# ENG-SF22030-R2-GEC-redlines.pdf Markup Summary

X:\25188.11\Drawings\Sheet\Grading\ES\Title.dwg, Initial: GESC (1), 4/27/2023 3:58:29 PM, CS

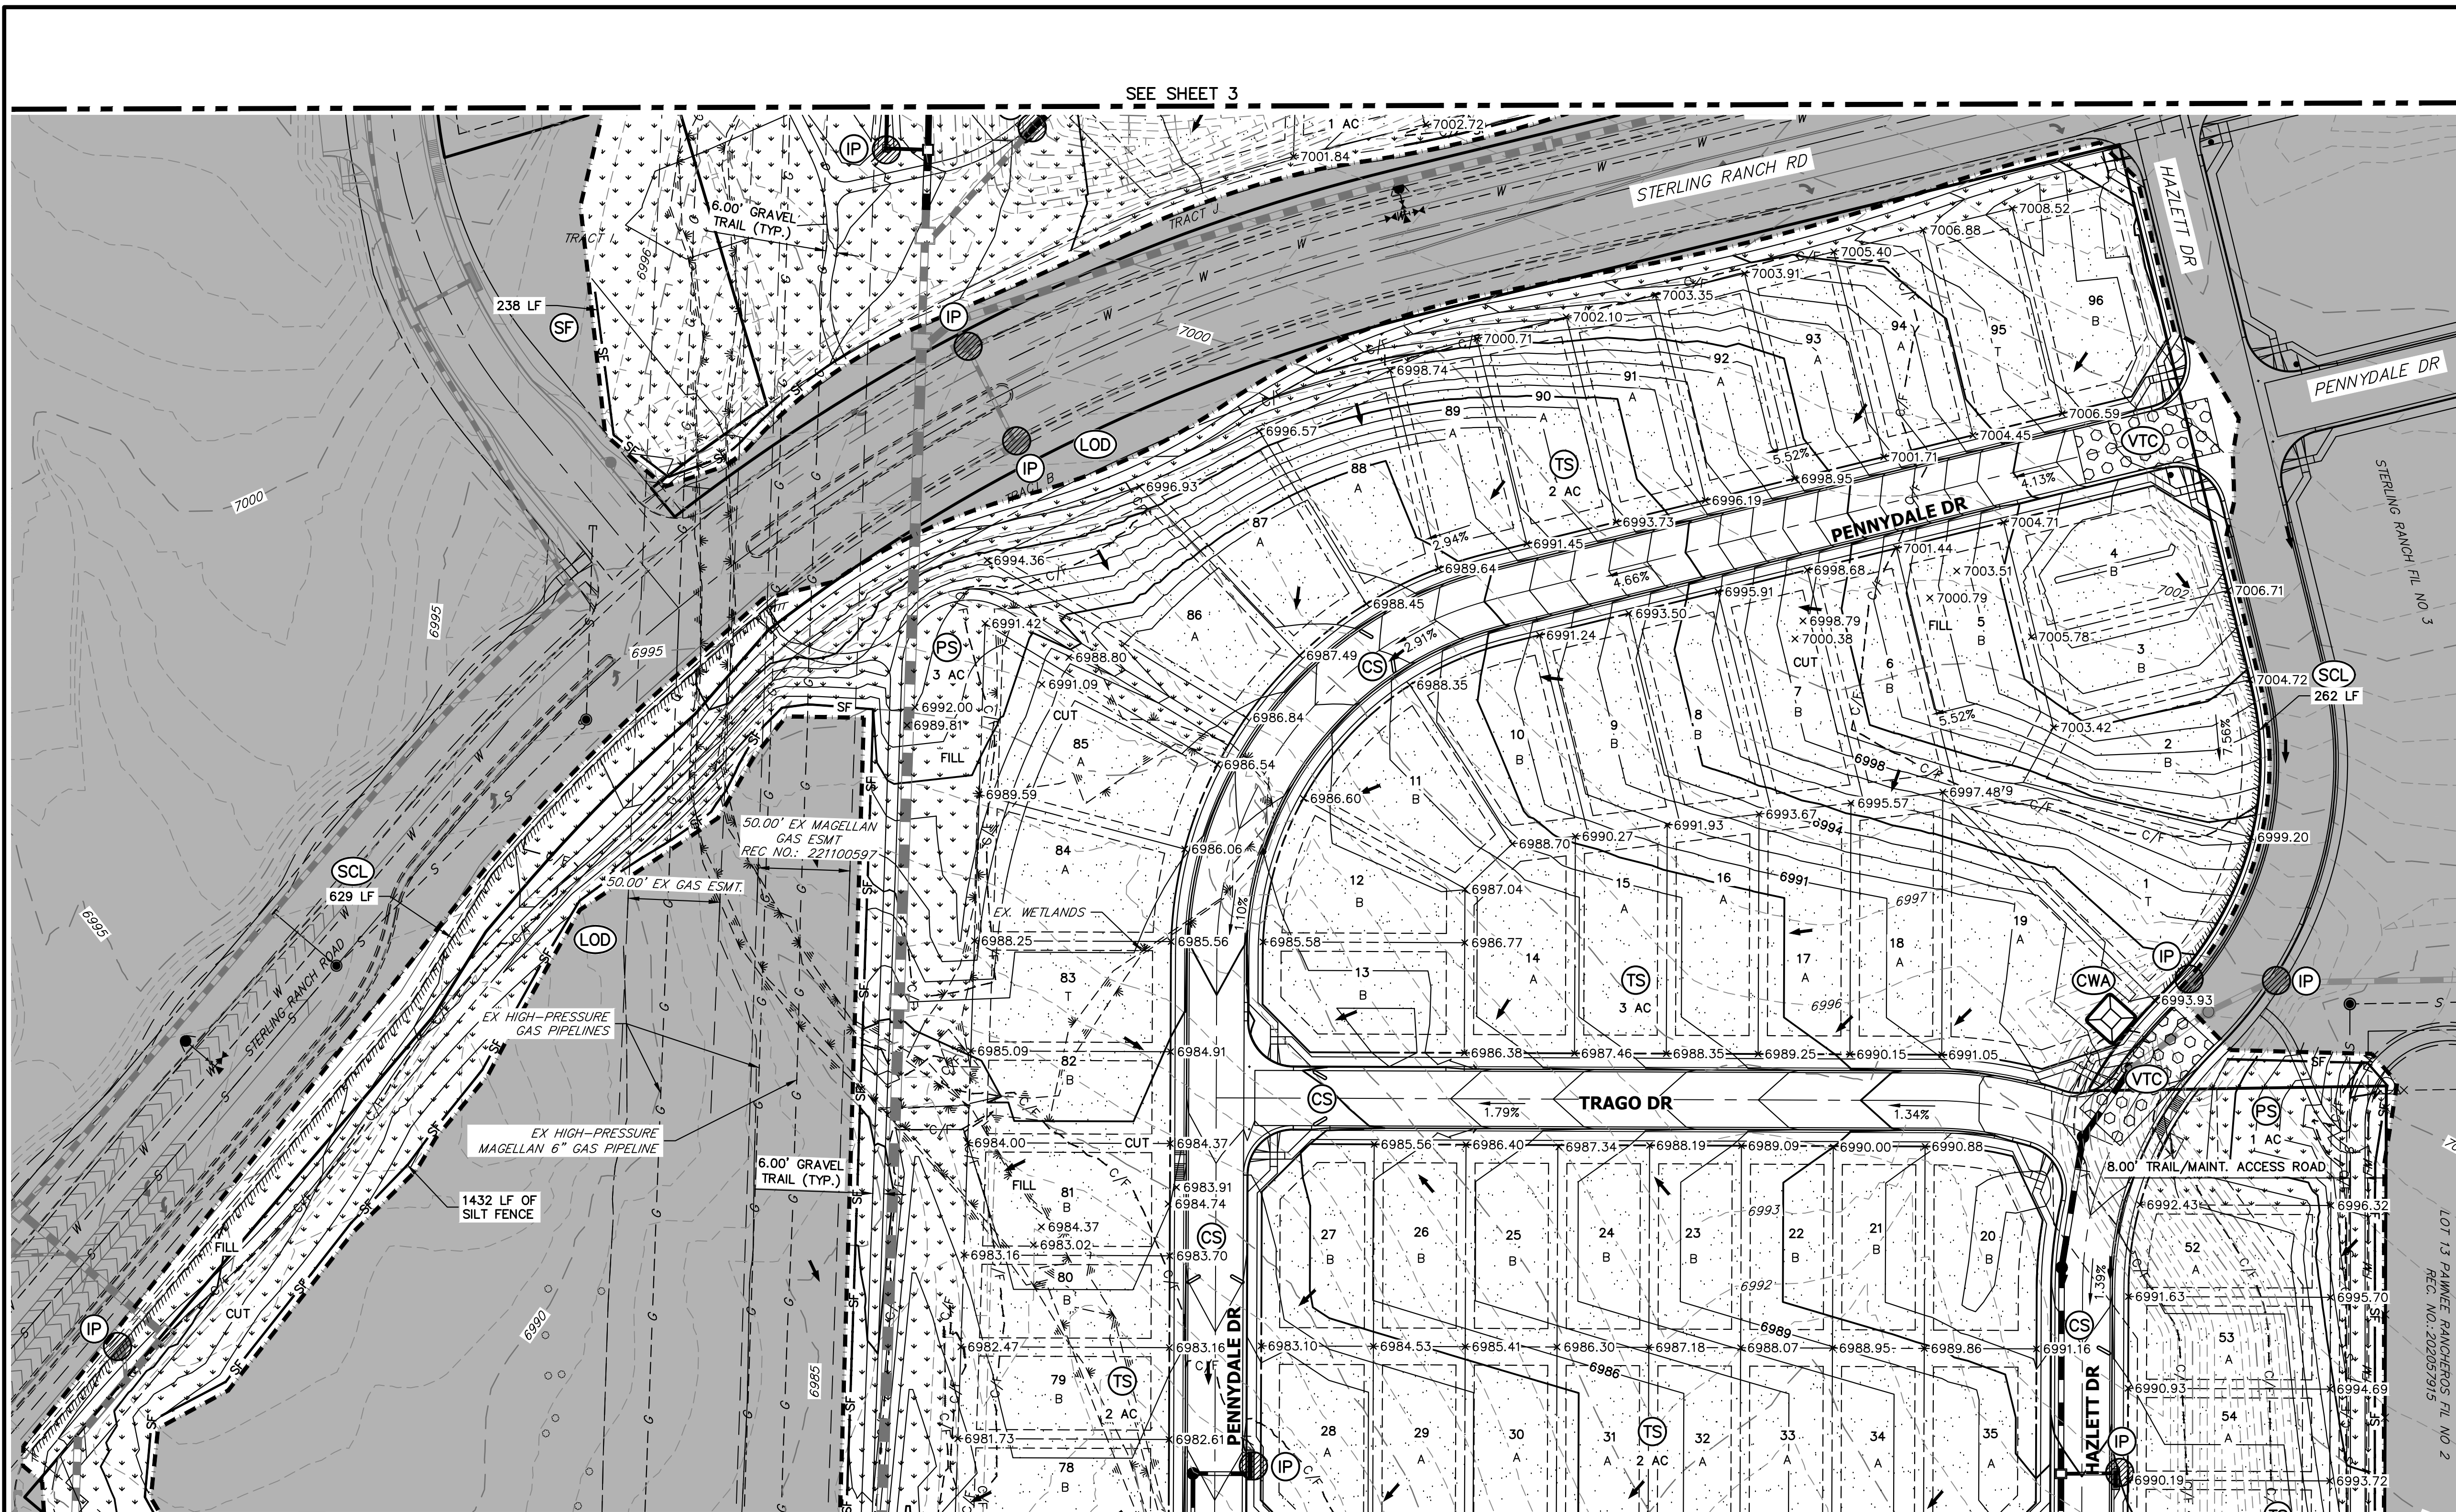
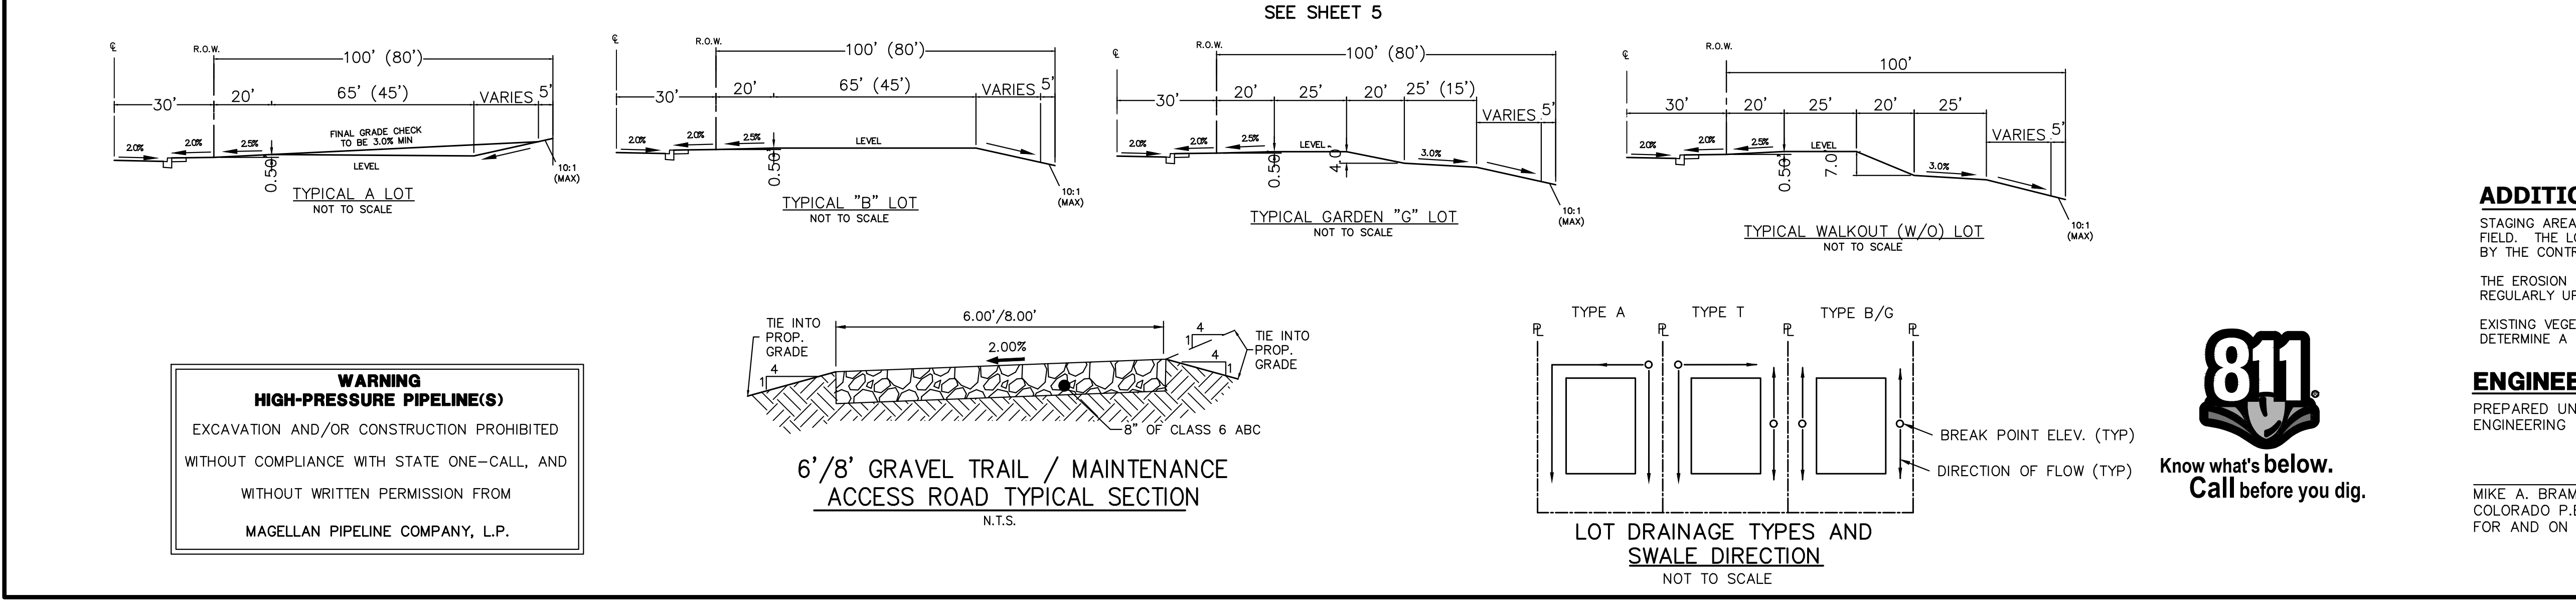
Update lot numbers to match the plat

Revise grading to elevate the lot

Label riprap

Label concrete channel

Is silt fence needed here?

Label offsite construction

Show property line

Label trail(?)

Ensure that grading allows for trail/ maint. access

Label trail

Provide trail/ maint. access road cross-section

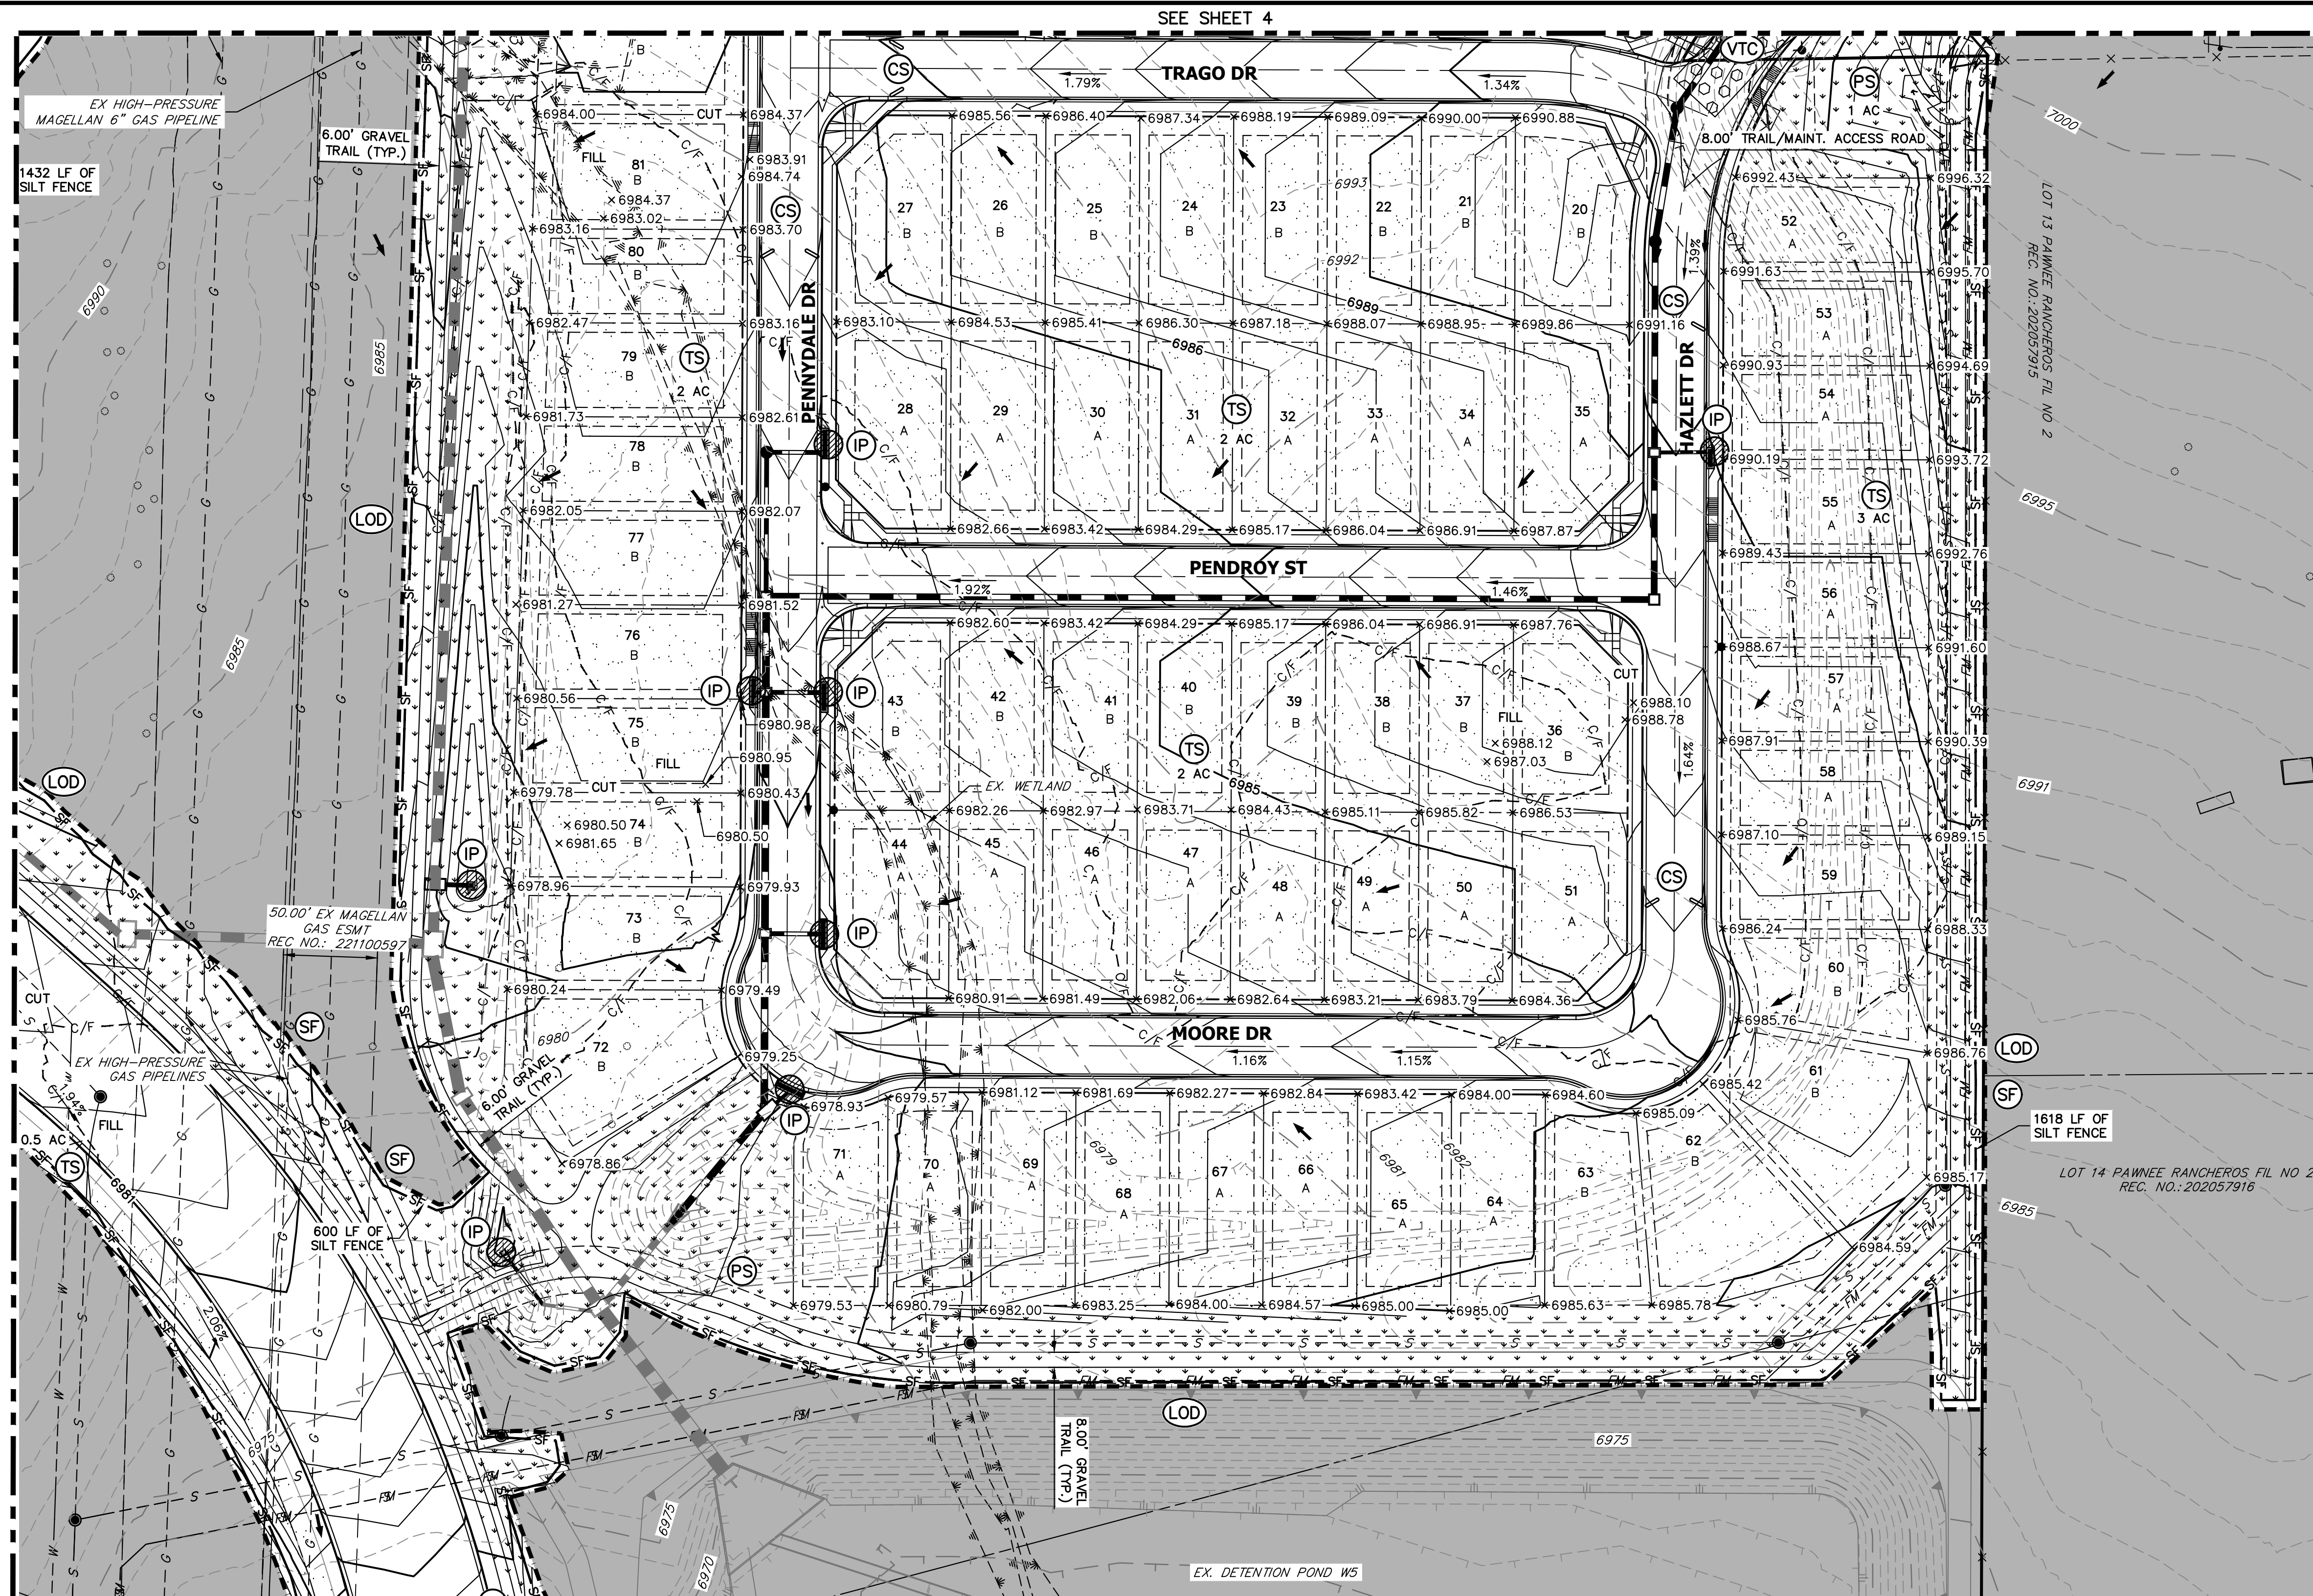
This grading is different from the previous submittal. Move the viewport limits over to the right to include entire limits of proposed grading area.
